**Application for Planning Permission for Works or Extension to a Dwelling**

**Development:** Single storey side extension and removal of 2 x chimneys  
**Location:** 1 Normandy Drive East Preston BN16 1LT

A :: Location Plan

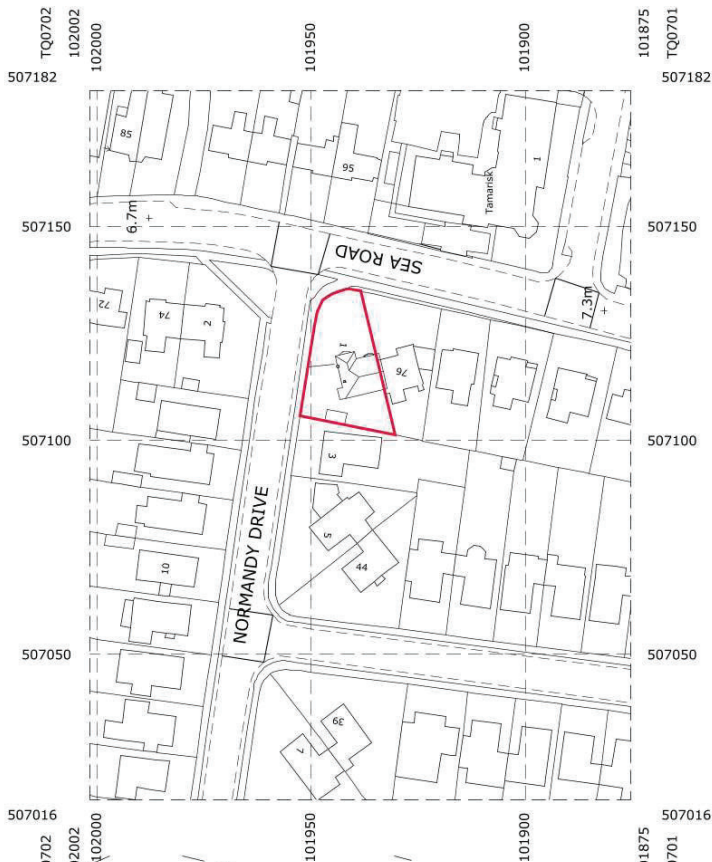
Location Plan: You are required to include a solid red outline around the proposed site on the location plan.
